Communities
Sport & Recreation

I refer to your approval dated the 23rd October, 2010 of a modification application in respect to Determination of Major Project 06_0232 for the Southern Highlands Regional Shooting Complex, Hill Top. That application was in respect to an oversight on the part of Communities NSW (Sport and Recreation) to notify the Department of Planning of a requirement to relocate the 500/200m ranges due to construction difficulties discovered following more detailed survey work. The approval validated earlier site clearing that, at the time, was outside the scope of the original site approval for the 500m range.

Figure 1. Drawing 21-17850-C003 Rev. 0 on the left incorrectly showing the range outside the survey area (dashed line), and proposed amended plan on the right, showing the range within the survey area.

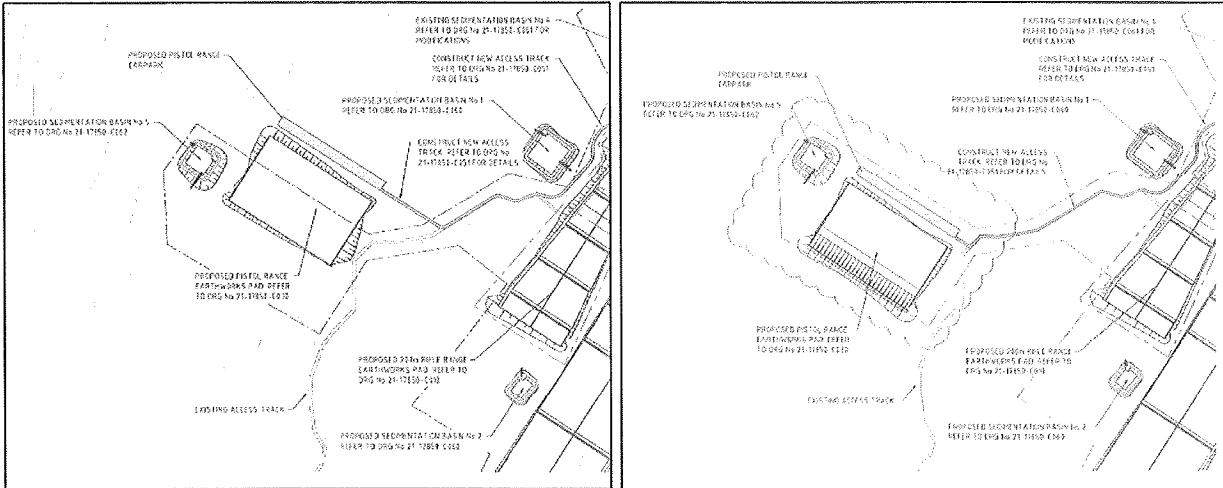
In providing Department of Planning officers with relevant site diagrams and drawings for the modification application, Drawing No 21-17850-C003 was included along with other documentation. It appears that an unintended consequence of providing that drawing - which subsequently was placed on the Department of Planning's website as part of the modification approval - was to show the site of the 50m pistol range in an area other than the original and intended location.

In view of the unintended consequences that arise from the inclusion of Drawing No 21-17850-C003 within documentation provided to the Department of Planning, and it being incorporated within your modification approval of the 23rd October, 2010, Communities NSW (Sport and Recreation) would seek a modification of that approval to validate the site location of the 50m range.

I can confirm that Communities NSW (Sport and Recreation) never sought or required that the site location of the 50m range be relocated from the position originally intended as per the Preferred Project Report July, 2008 incorporated within the 1st March, 2010 Determination of the Minister for Planning.

I attach a Section 75W modification application. A revised site location drawing is being prepared by our consultants and will be lodged immediately with your agency to allow the application to be finalized.
